**Subject:** RE: Planning Consultation on: A/64/21/PL

Please see Private Sector Housing comments below. These comments are in relation to general housing conditions and have regard to the Housing Act 2004, Housing Health and Safety Rating System (England) Regulations 2005 and LACoRS national fire safety guidance, where applicable.

**Application No:** A/64/21/PL  
**Registered:** 26th March 2021  
**Site Address:** Former Shrublands Nursery Roundstone Lane Angmering BN16 4AT  
**Grid Reference:** 507314 103492  
**Description of Works:** Demolition of existing buildings & erection of 40 No. residential dwellings including 12 No. (30%) affordable units & associated landscaping, road layout, parking & provision of Public Open Space. This site is in CIL Zone 2 & is CIL Liable as new dwellings.

Drawing Title
Proposed Plans
Plots 29,30,31,32,33,34

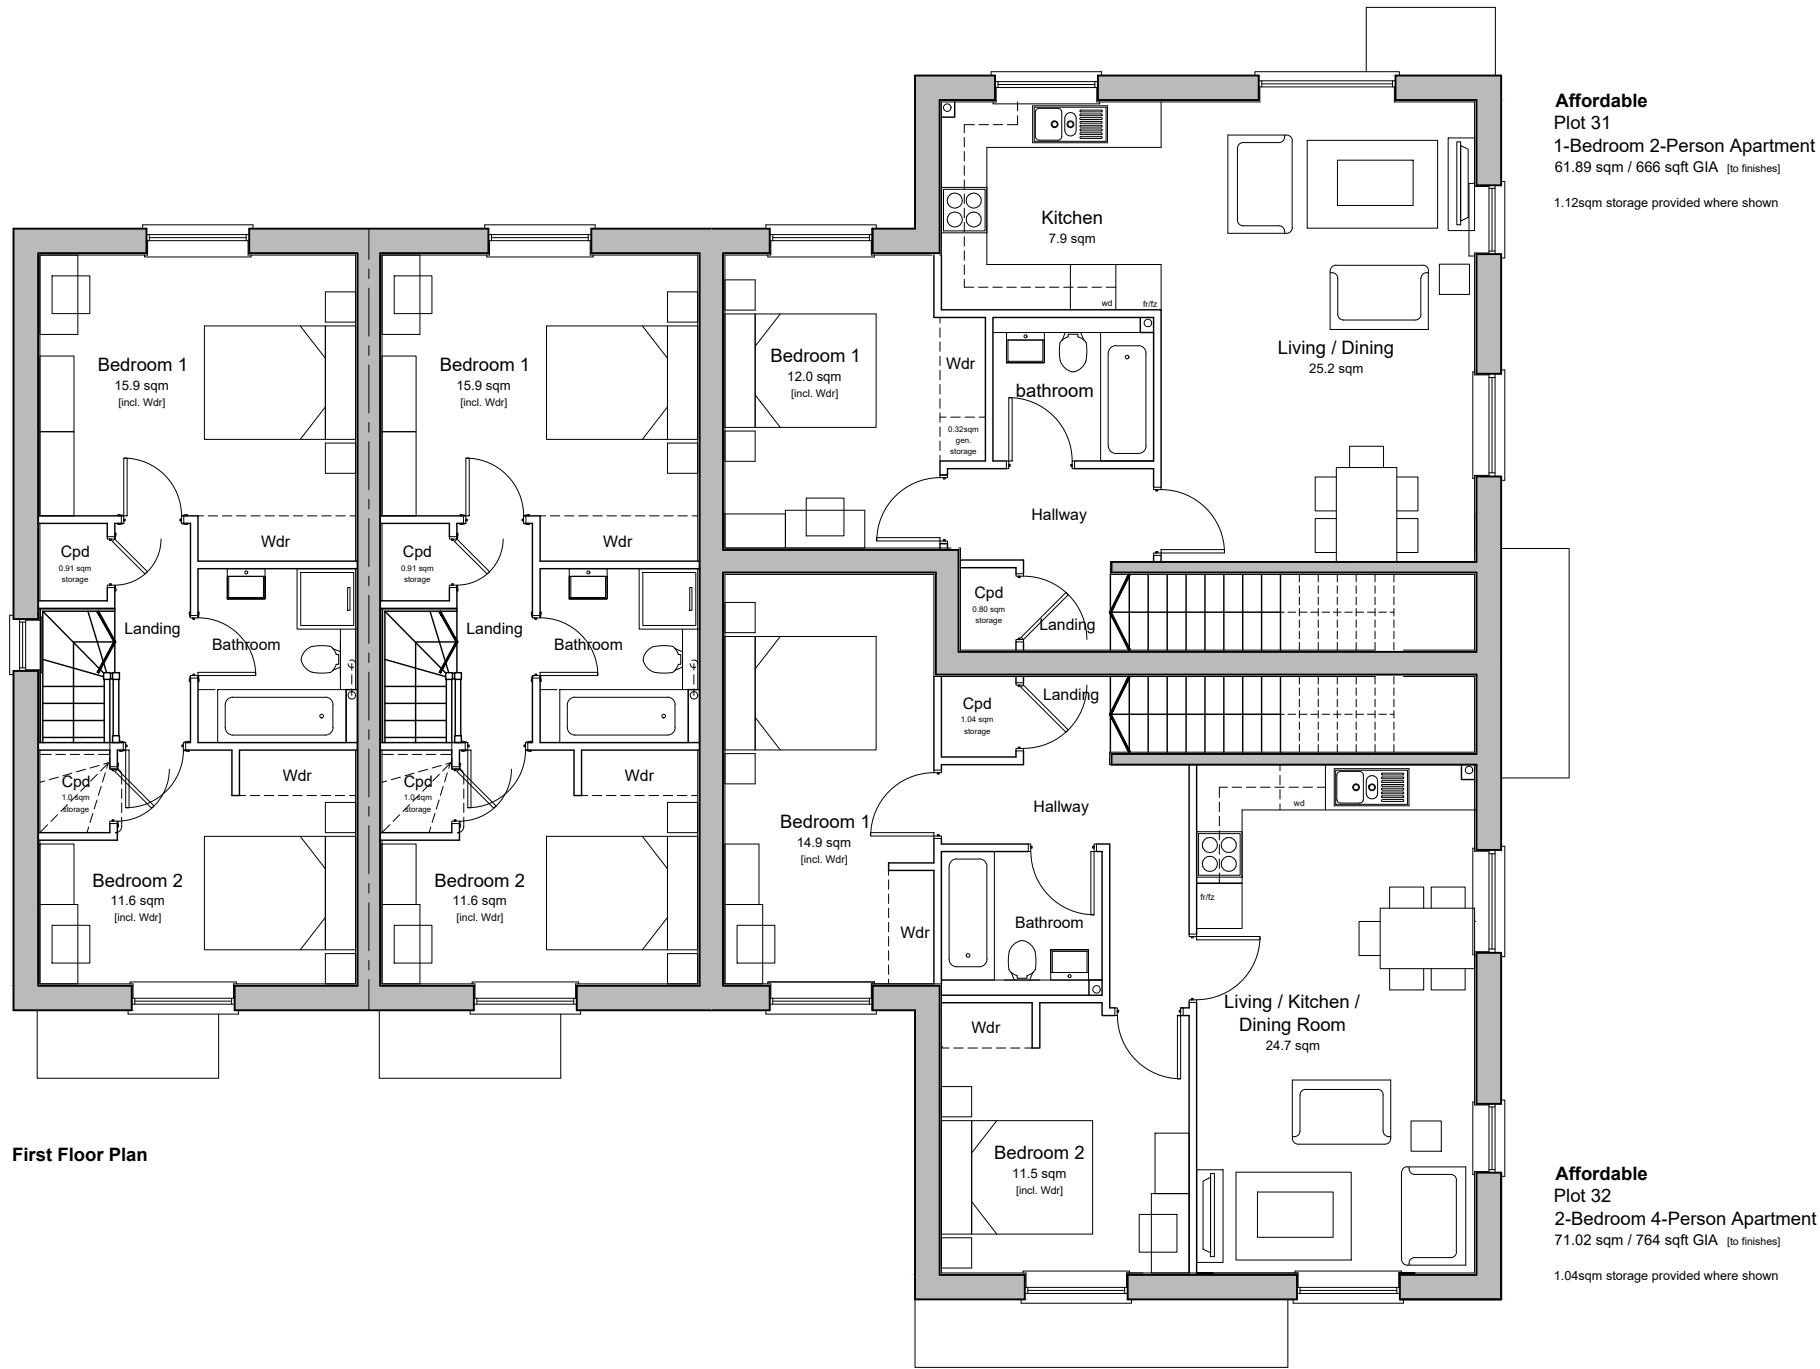
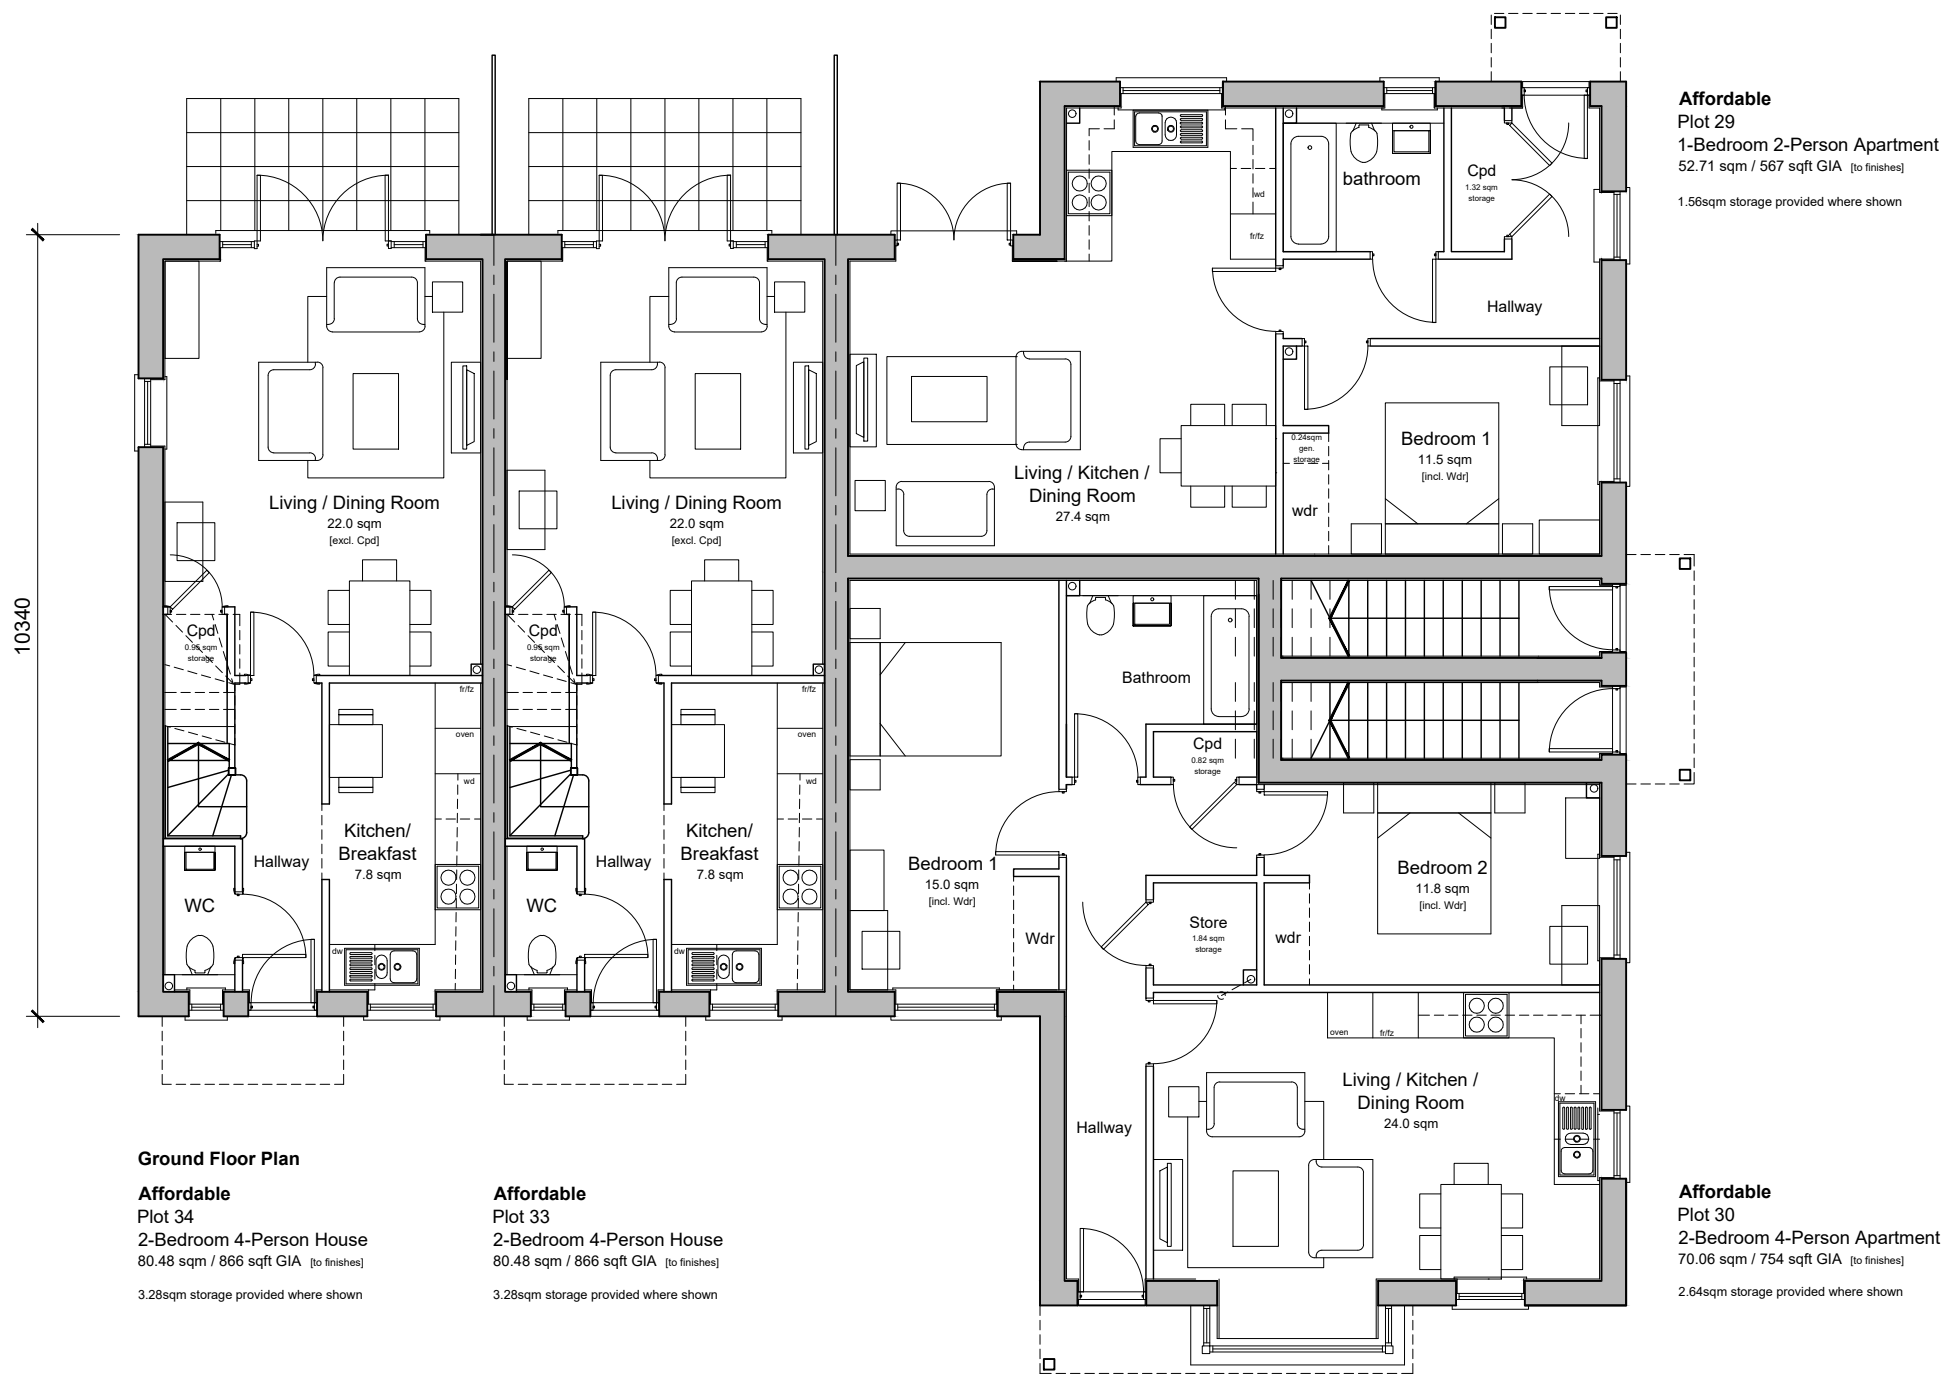
- A room where the only escape route is through another room is termed an “inner room” and poses a risk to its occupiers if a fire starts unnoticed in the outer room. Egress from bedroom 1 in Plot 29 is via the open plan living/kitchen/dining room; this can be overcome by ensuring that the window in the bedroom is an escape window and adequate fire protection is provided within the flat. N.B. An escape window should only be installed if the following criteria can be met:
  - They serve rooms whose floor level is no more than 4.5m from the ground;
  - Every room served by the escape window has access to it without entering another habitable room;

- Egress from all bedrooms in Plots 33, 34, 39 & 40 are also not ideal as the foot of the staircase is situated directly opposite the kitchen which has not been fitted with a door. Consideration needs to be given to either providing a door to each kitchen or to install escape windows within each bedroom, providing the above criteria can be met

- Grade D1 interlinked fire detection should be installed to Plots 29 & 31 and Plots 30 & 32
  - Fire blankets should be provided to all kitchen areas
